A585 Windy Harbour to Skippool Improvement Scheme

7.11 Environmental Statement Changes and Corrections Document

August 2019

Rev	Status	Rev. Date	Purpose of revision	Drawn	Check'd	Appr'd
1	SS	MAY19	S8 - DEADLINE 2 SUBMISSION	JN	KB	NH
0	SS	OCT18	S8 - DCO SUBMISSION	JN	KB	NH

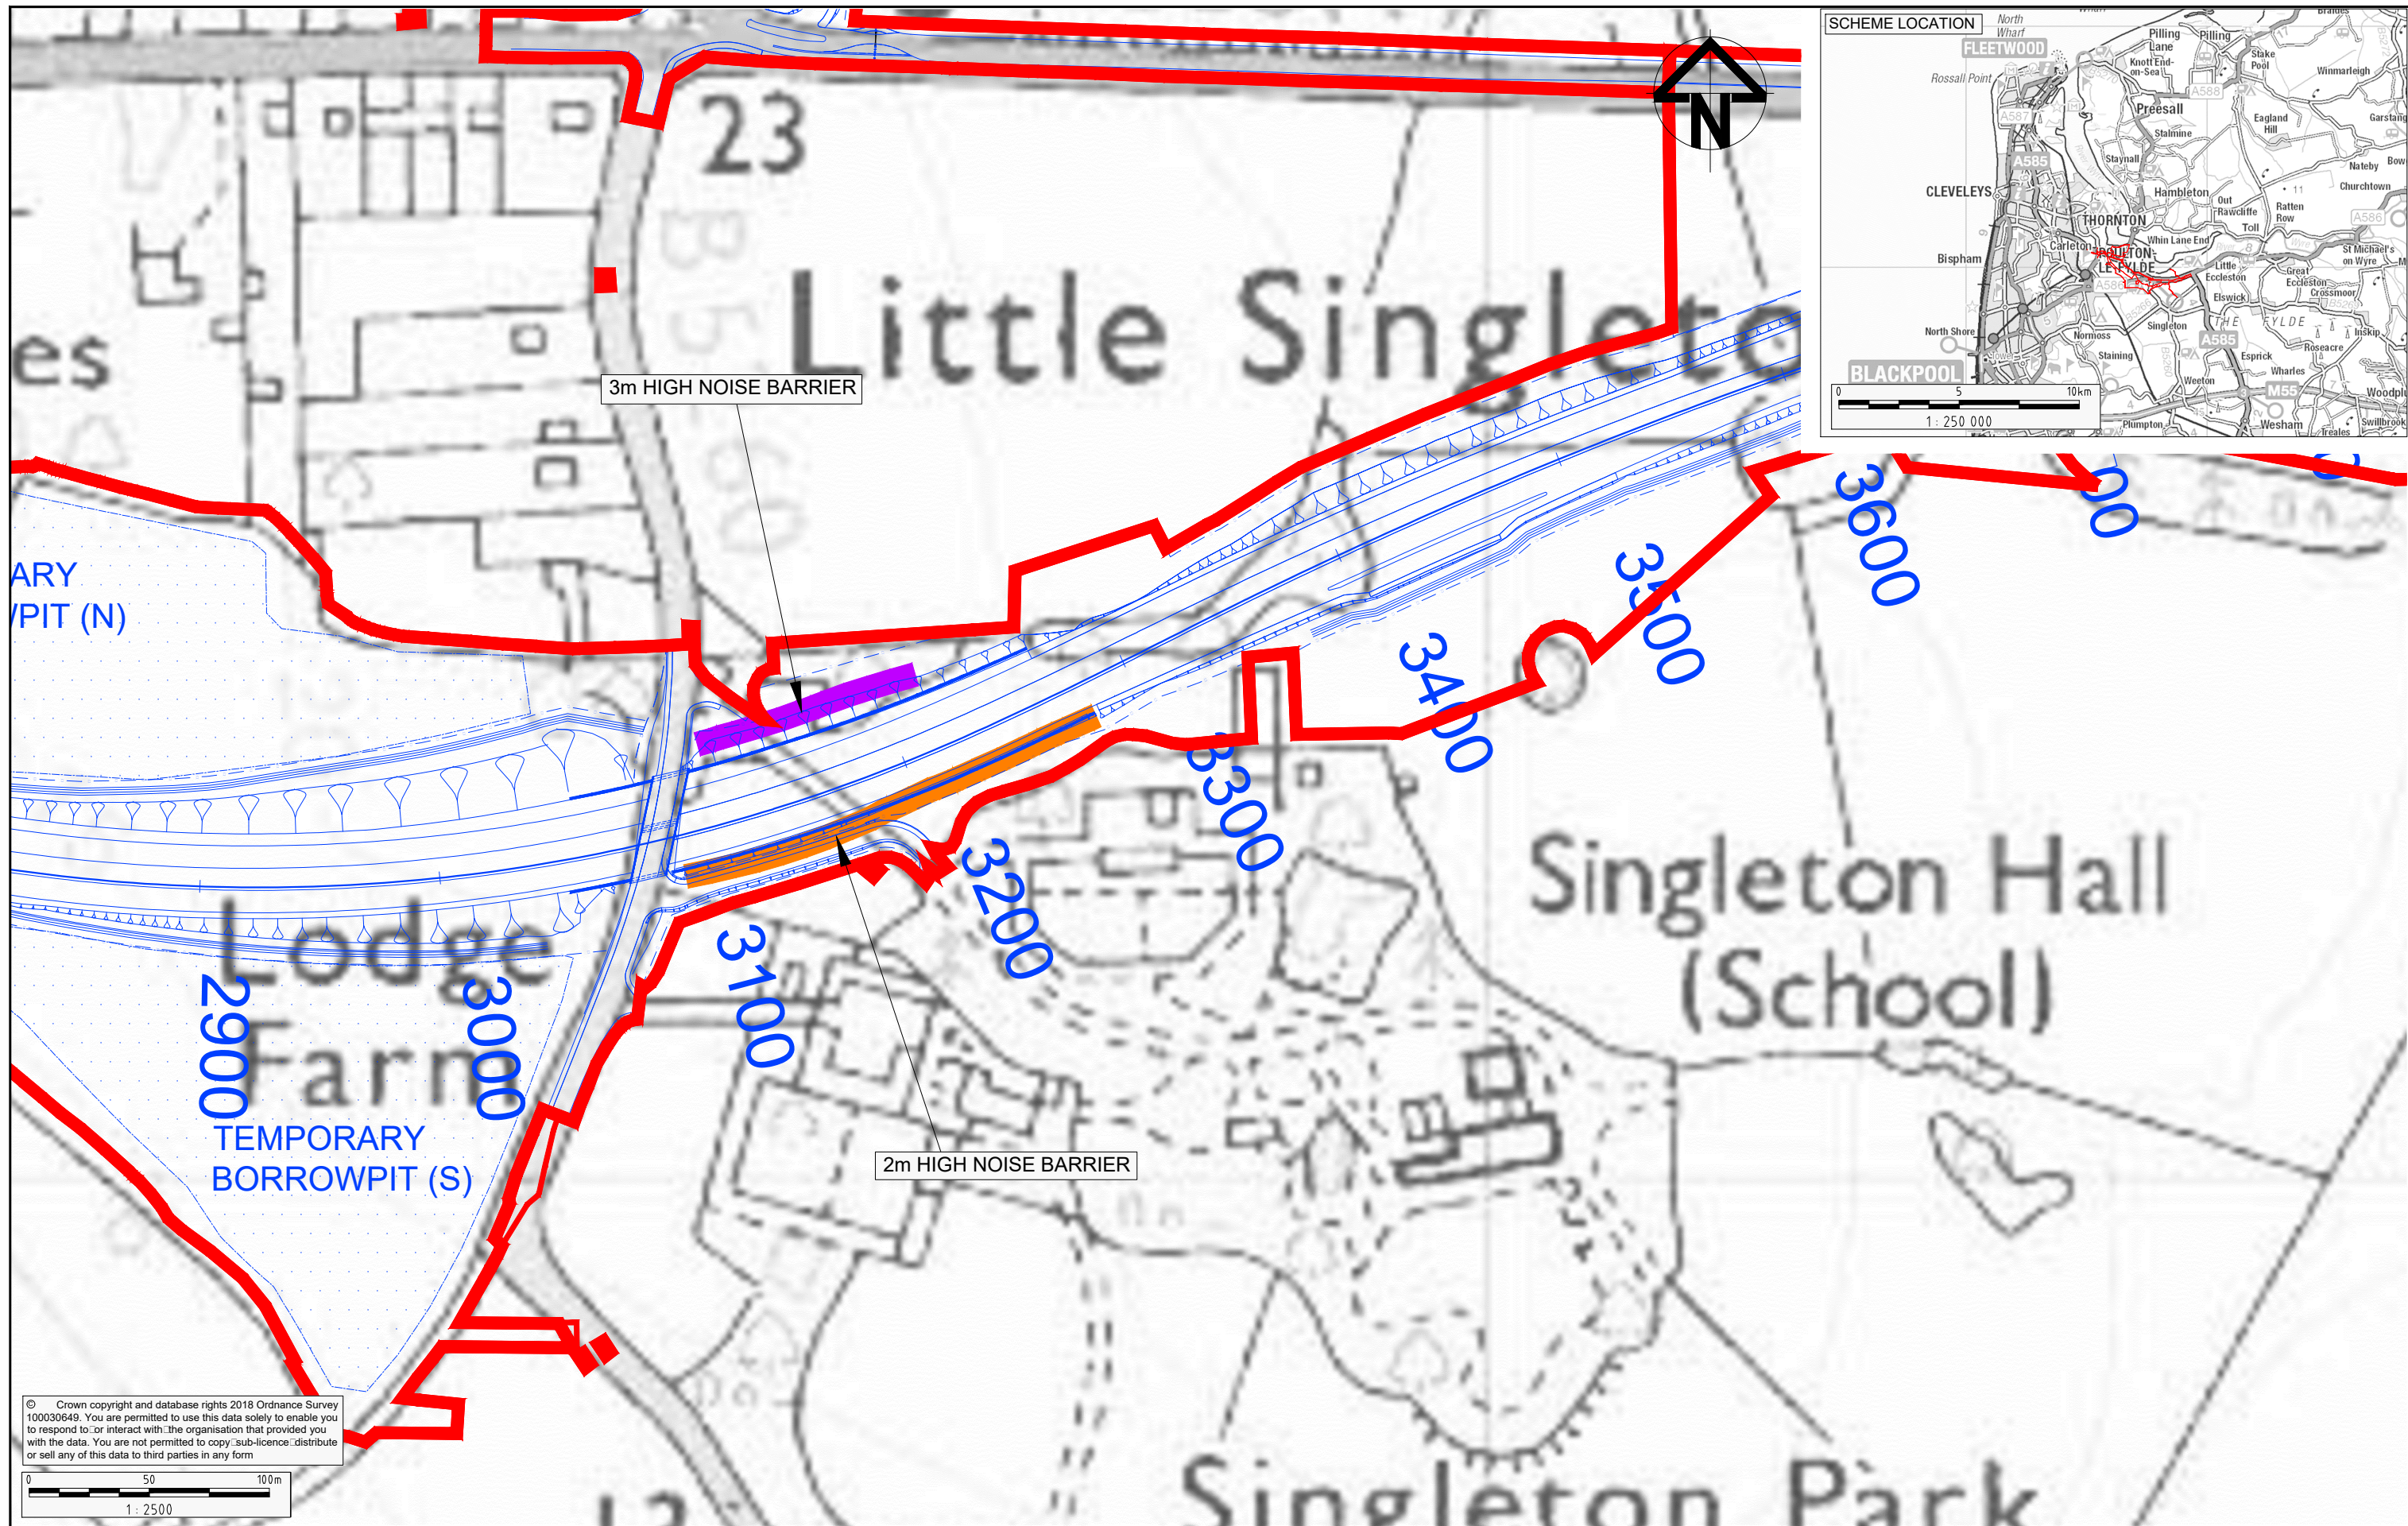
Document Reference Number	Document Name	Amendment Required	Reason
			TR010035/APP/7.10).
6.11	ES Chapter 11: Noise and Vibration	Update to Figure 11.4: Noise and Vibration – Noise Mitigation within the Study Area presented at Appendix D to show heights and locations of earth mounds and acoustic fencing at a larger scale.	Requested by the Inspector within the first round of written questions (document reference TR010035/APP/7.10).

APPENDIX F – Updated Figure 12.2: Road Drainage and The Water Environment - Aquifers

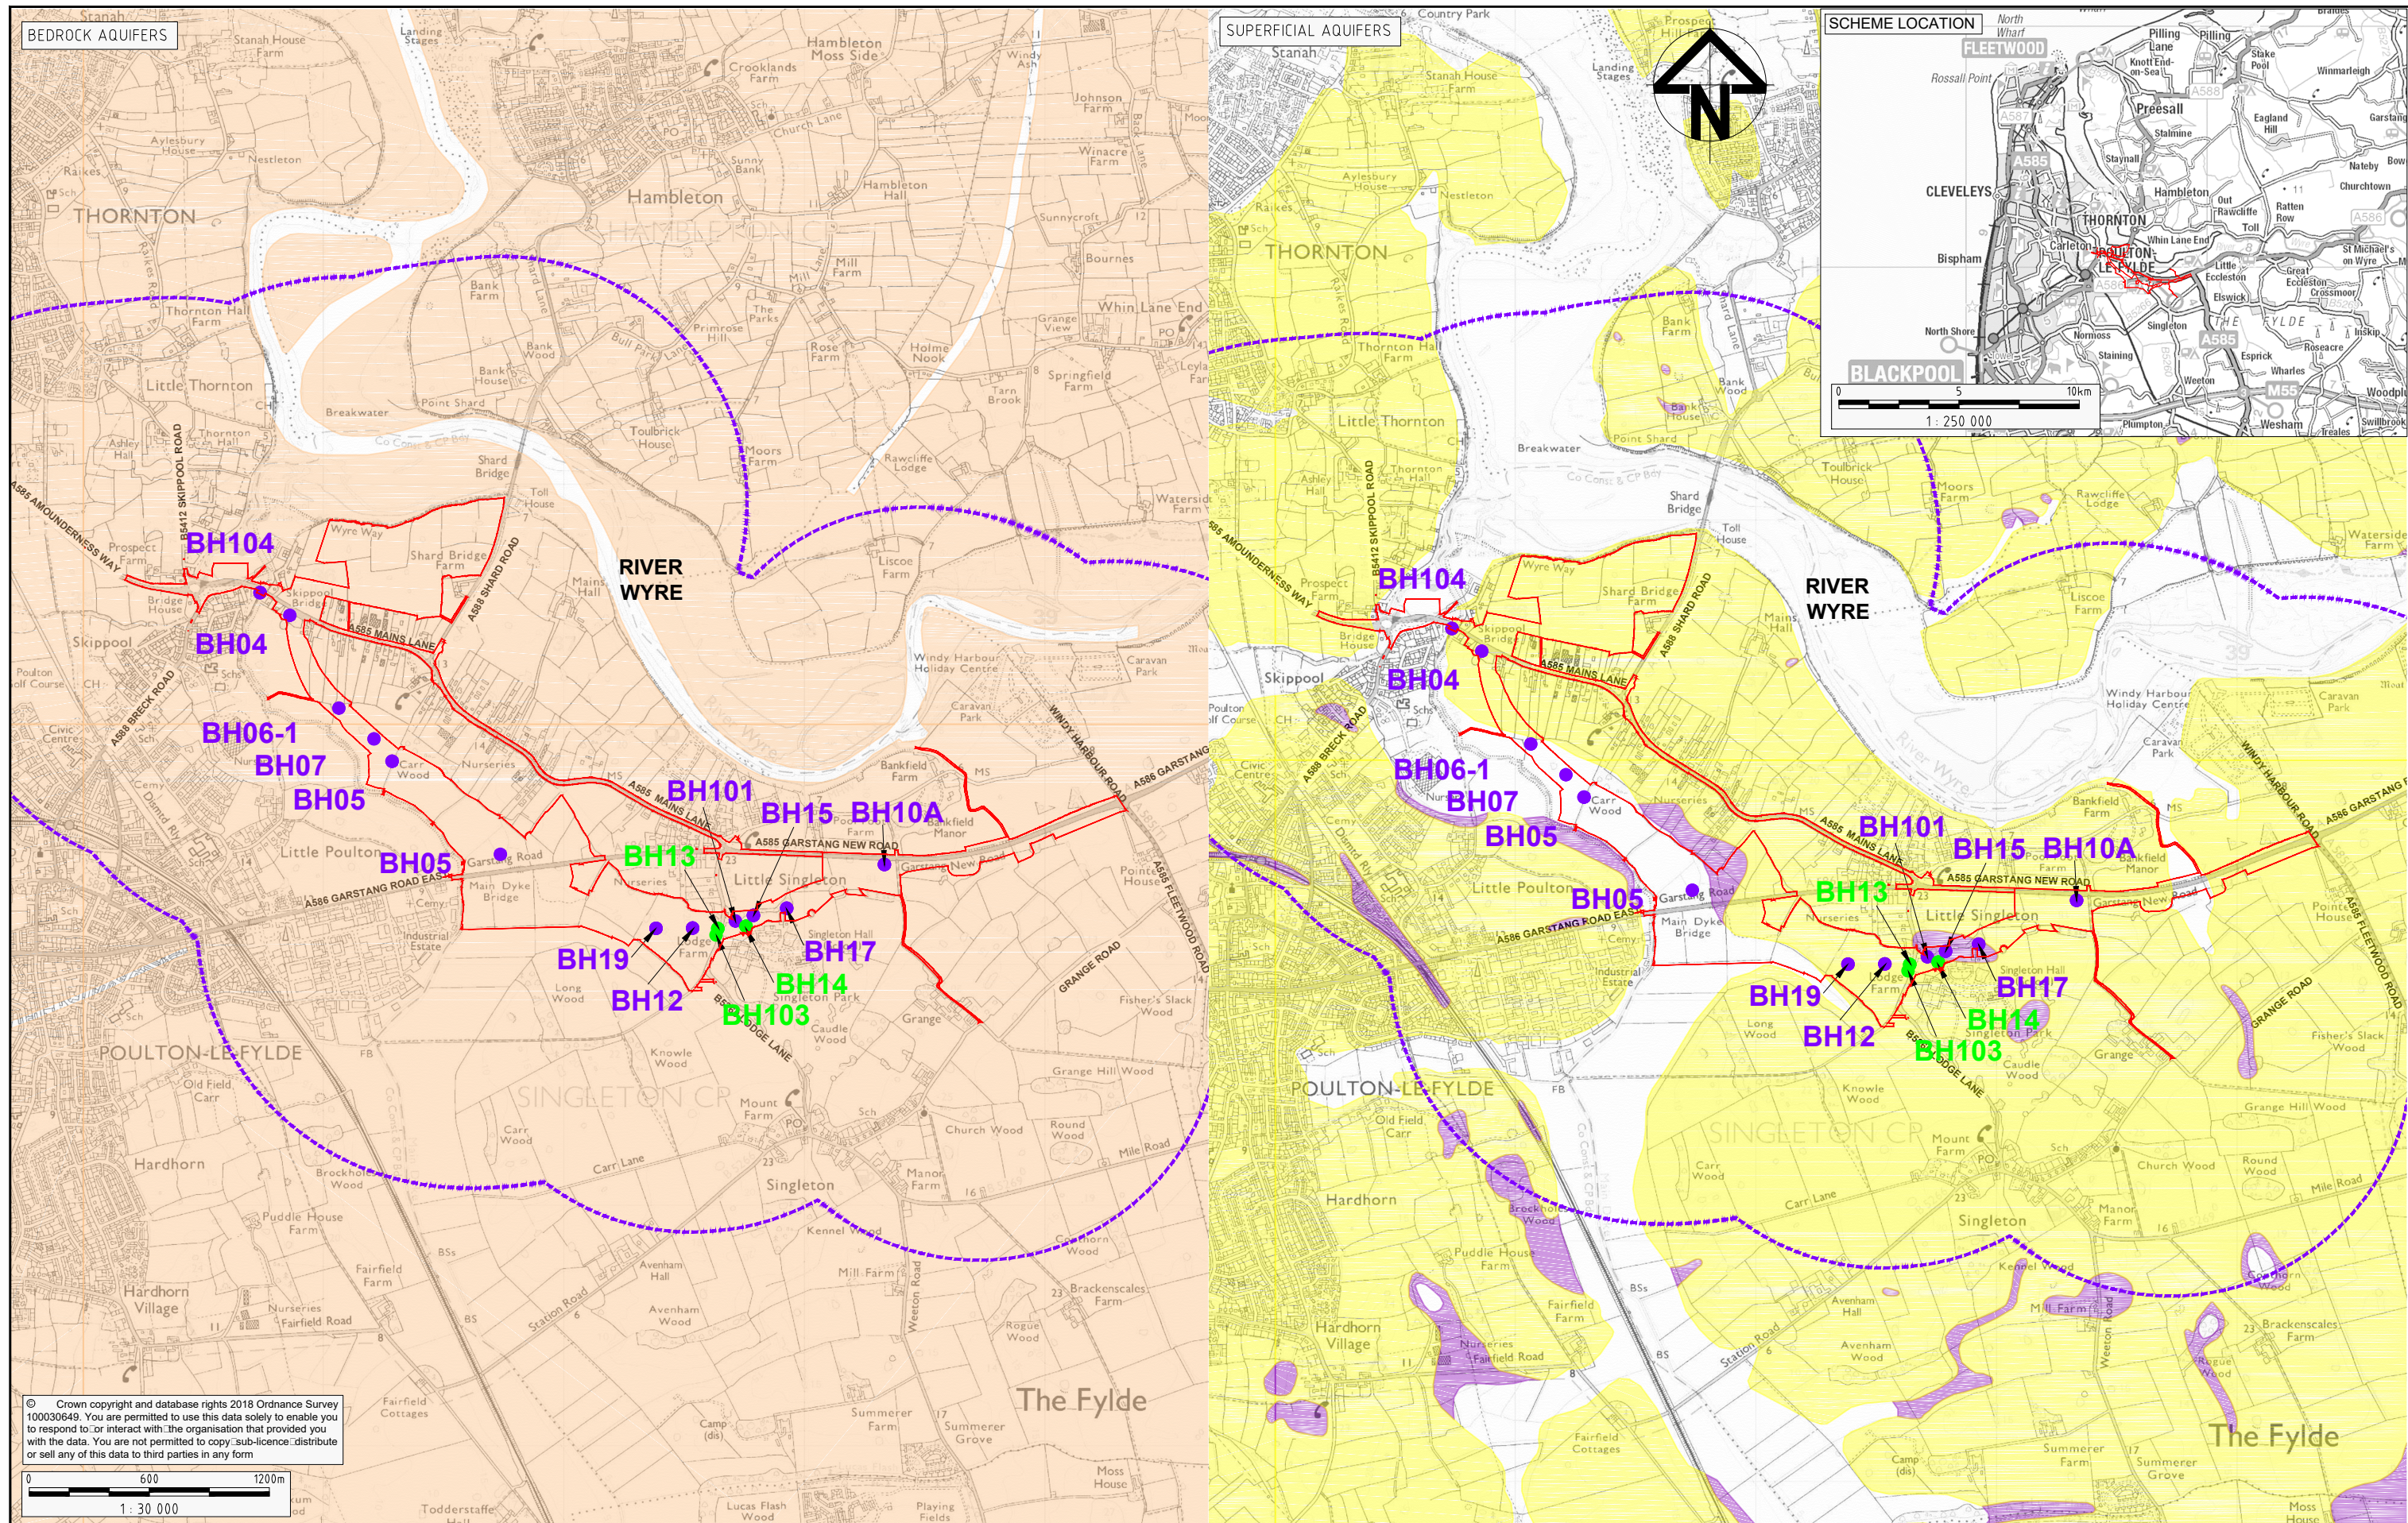
Appendix E – Updated Table 4-1 within Appendix 11.3 (document reference TR010035/APP/6.11.3).....	34
Appendix F – Updated Figure 12.2: Road Drainage and The Water Environment - Aquifers	36

Insert 12-3: Road Drainage and the Water Environment - Maximum flood Extents in Baseline and with Scheme (option model) Scenarios (0.5% AEP tidal event)

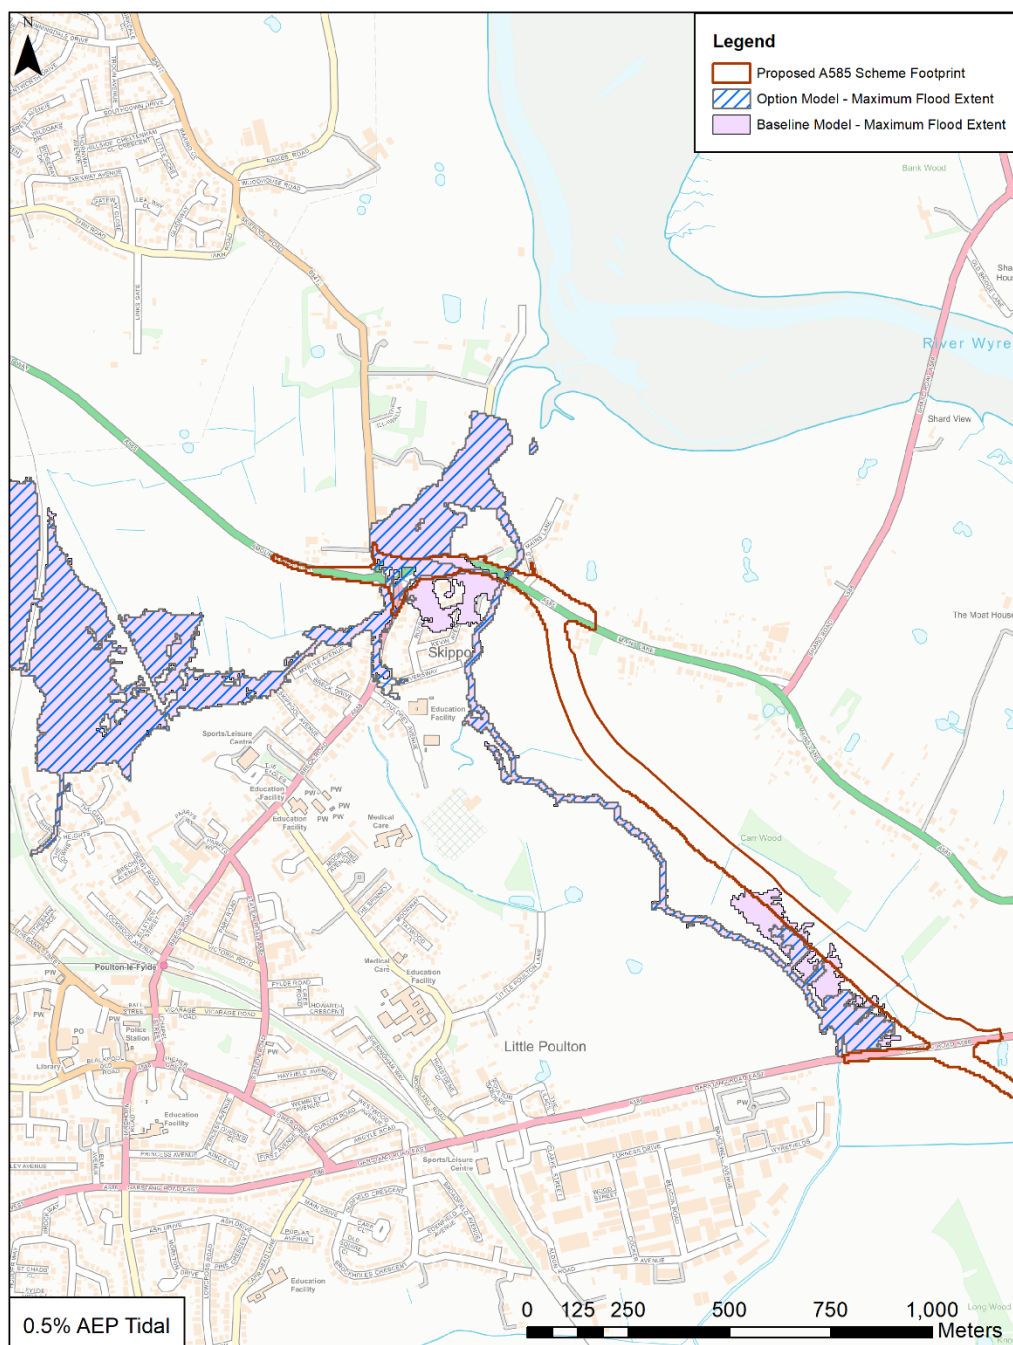
Document Reference Number	Document Name	Amendment Required	Reason
6.12	ES Chapter 12: Road Drainage and the Water Environment	<p>Paragraph 12.7.23</p> <p>During the 0.5% annual chance event, as illustrated in Insert 12-3, with the Scheme in place there is a reduction in flood risk to a number of these properties, that are predicted to be prevented from flooding. This is because an increase in the vertical alignment of the Scheme at this location prevents water from overtopping the road and flowing into this area. Instead, more water pools behind the road embankment to the north and flows upstream (south) along the Horsebridge Dyke dwarf walls included in the Scheme design immediately east of Skippool junction reduce the volume of floodwater overtopping the road and flowing into this area. The magnitude of change is assessed as Moderate Beneficial. Combined with the High value of the flood flow/storage attributes of the tidal floodplain, this results in an effect with an overall significance of Moderate Beneficial. In terms of the EIA Regulations this effect is considered Significant (positive).</p>	As a result of the updates made to the Flood Risk Assessment (document reference TR010035/APP/5.2 – Rev 1).

6.12	ES Chapter 12: Road Drainage and the Water Environment	Replacement Insert 12-3: Road Drainage and the Water Environment - Maximum Flood Extents in Baseline and with Scheme (option model) Scenarios (0.5% AEP tidal event).	As a result of the updates made to the Flood Risk Assessment (document reference TR010035/APP/5.2 – Rev 1).
